Rezoning Transportation Analysis

Petition Number: 2023-022

General Location Identifier: 02954104

Revision Log:

SCHEMATIC SITE PLAN

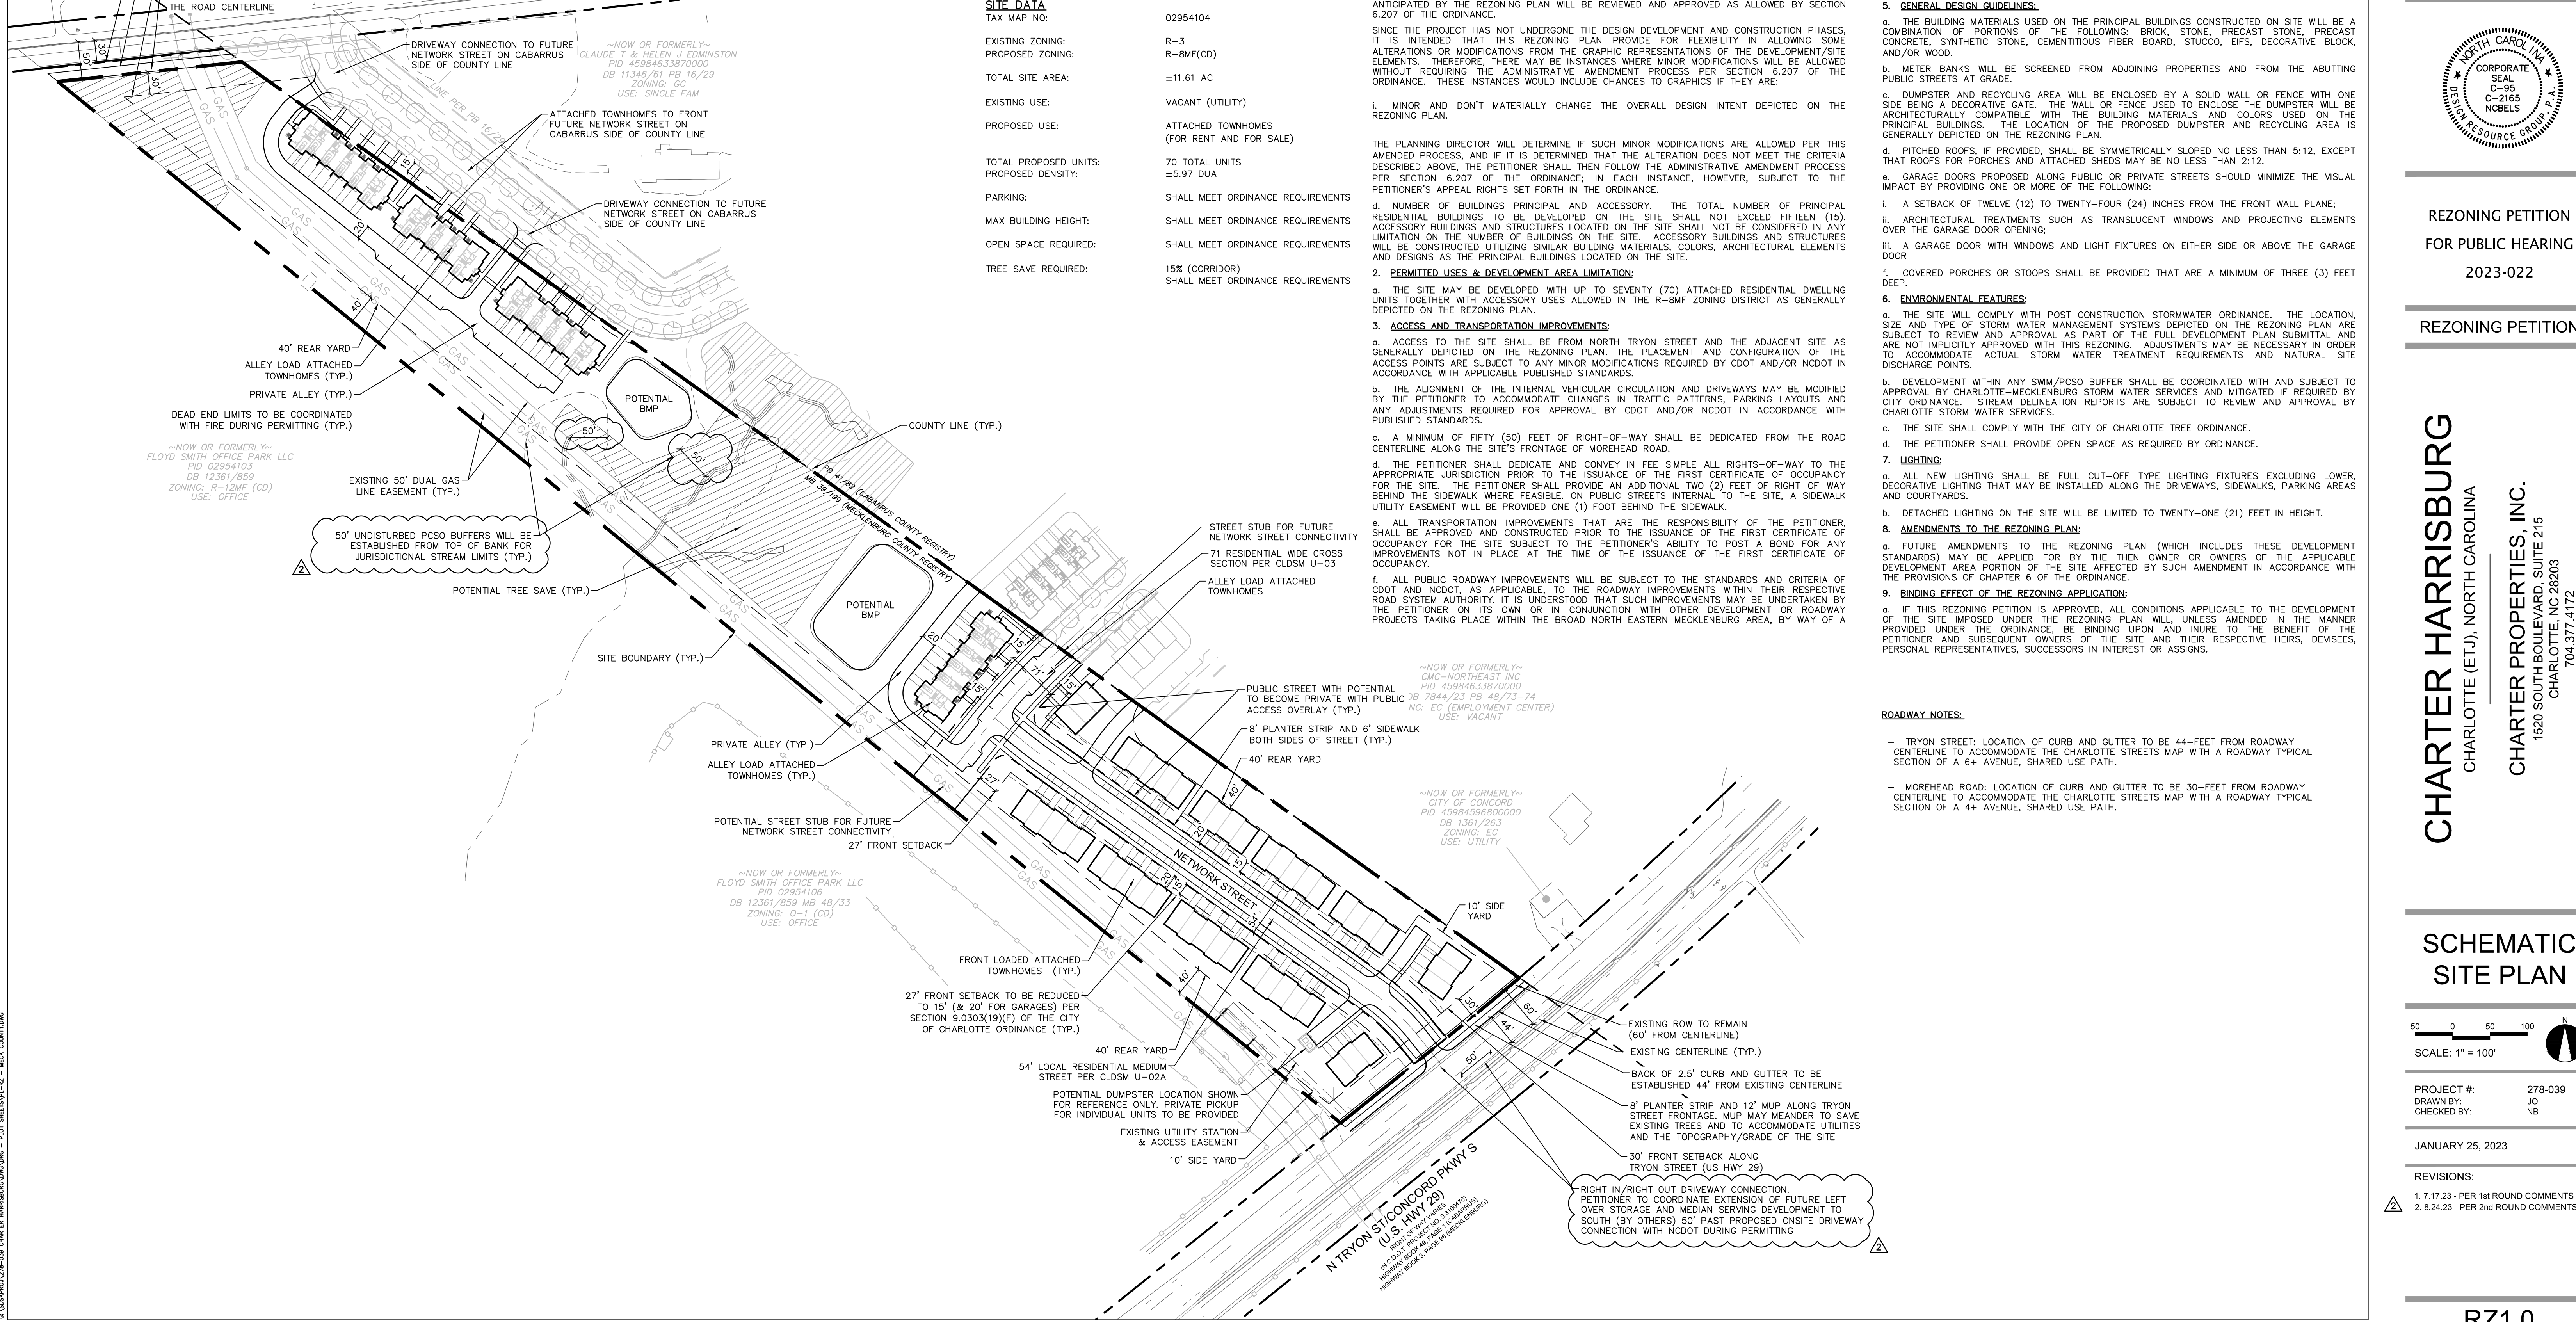
1. ~~Curbline:~~

a. ~~Tryon Street:~~ Location of curb and gutter to be 44 feet from roadway centerline to accommodate the Charlotte Streets Map with a roadway typical section of a 6+ Avenue, Shared Use Path.

b. ~~Morehead Road:~~ Location of curb and gutter to be 30 feet from roadway centerline to accommodate the Charlotte Streets Map with a roadway typical section of a 4+ Avenue, Shared Use Path.

Label and dimension the curb and gutter from the centerline for each road on the site plan.

6. Revise site plan and conditional note(s) to commit to removing the Tryon Street Access point in coordination with NCDOT. Site shall utilize the internal street network within the adjacent development.

11. Revise site plan and conditional note(s) to construct a 8-foot planting strips and 12-foot multi-use paths on Tryon Street and Morehead Road. The site plan shall label and dimension both items from the back of curb and gutter or edge of pavement. Add conditional note the entire facility must be outside of the right of way and within a public access easement. Add conditional note committing to construction and maintenance of the 12-foot multi-use paths on Tryon Street and Morehead Road.
